From: [Eve, David](#)
To: [Great Yarmouth Third River Crossing](#)
Subject: Great Yarmouth Third River Crossing (ref TR010043)
Date: 03 October 2019 16:10:01
Attachments: [7.5\(d\) - GYTRC SoCG - Historic England.pdf](#)
[Third River Crossing Great Yarmouth HE reps 10.19.pdf](#)

**APPLICATION BY NORFOLK COUNTY COUNCIL FOR AN ORDER GRANTING
DEVELOPMENT CONSENT FOR THE PROPOSED THIRD RIVER CROSSING,
GREAT YARMOUTH**

APPLICATION REF: TR010043

**REPRESENTATIONS OF THE HISTORIC BUILDINGS AND MONUMENTS
COMMISSION FOR ENGLAND (HISTORIC ENGLAND)**

Figure 1

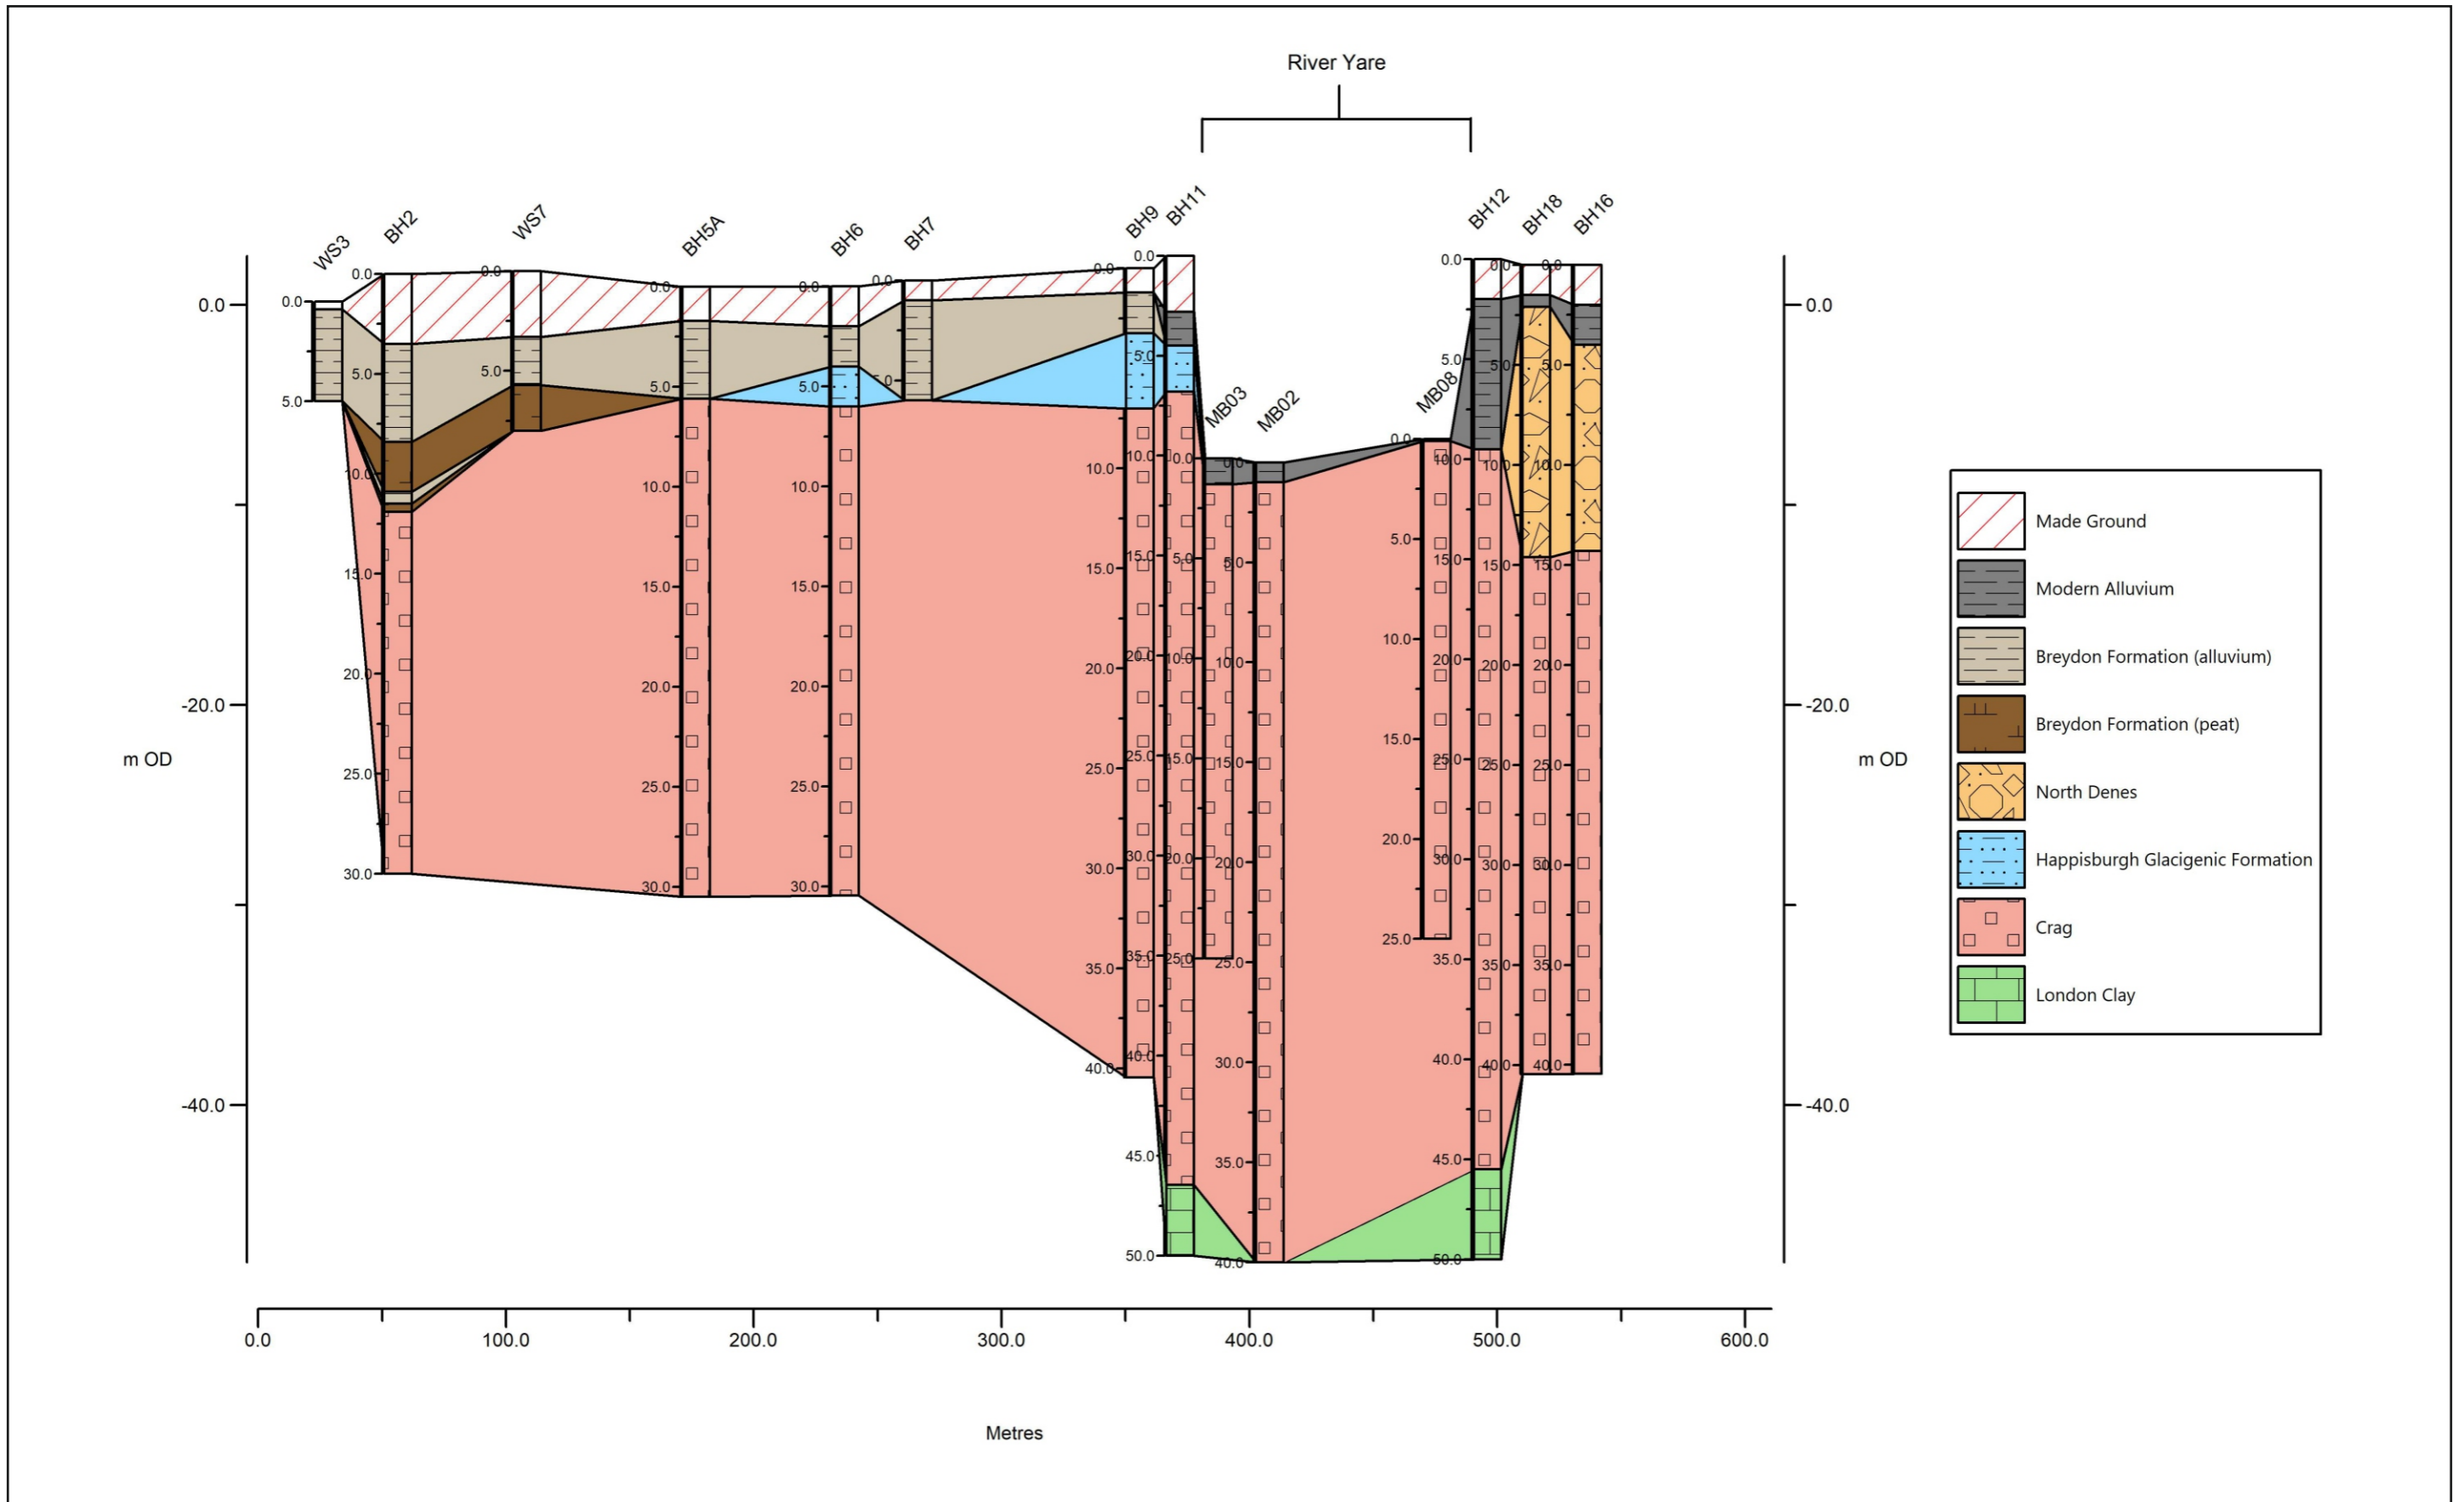
4.9 Wessex Archaeology were commissioned to carry out a review of geotechnical borehole data collected as part of the ground investigations works. The geoarchaeological investigations will follow a five-staged process, which has been summarised in Table 1. The report presented in Appendix 9C represents the Stage 1 report, the geoarchaeological review, which aims to identify deposits of archaeological potential. The cores were collected using either a cable percussion rig or a window sampling rig (Section 4.1.3 & 4.1.4). Only the window samples allowed for continuous, undisturbed samples to be collected, but subsequent geotechnical assessments mean they are no longer undisturbed and therefore not suitable for geoarchaeological recording and subsampling (Sections 4.1.4 & 7.1.2). A total of 48 geotechnical logs were reviewed and a deposit was produced (Section 4.3 & Figure 2).

4.10 A review of the deposits model has identified areas of archaeological potential, in particular the Breydon Formation, as well as the questions that need to be addressed. For example, it is acknowledged that it is not possible to establish which of the expected peat accumulations have been recorded on site, and that additional palaeoenvironmental analysis would be required (Section 6.1.11). It is therefore recommended that a dedicated geoarchaeological borehole surveys is undertaken to recover undisturbed core samples from the Breydon Formation deposits with the potential for further palaeoenvironmental works to take place if necessary (Section 7.1.3). We agree with these suggestions and feel that they are sensible and appropriate. We would recommend that the number of dedicated geoarchaeological boreholes that will be collected is considered carefully to ensure that they address the questions remaining about the archaeology, the impact the proposed works may have and the information needed to define a suitable mitigation strategy.
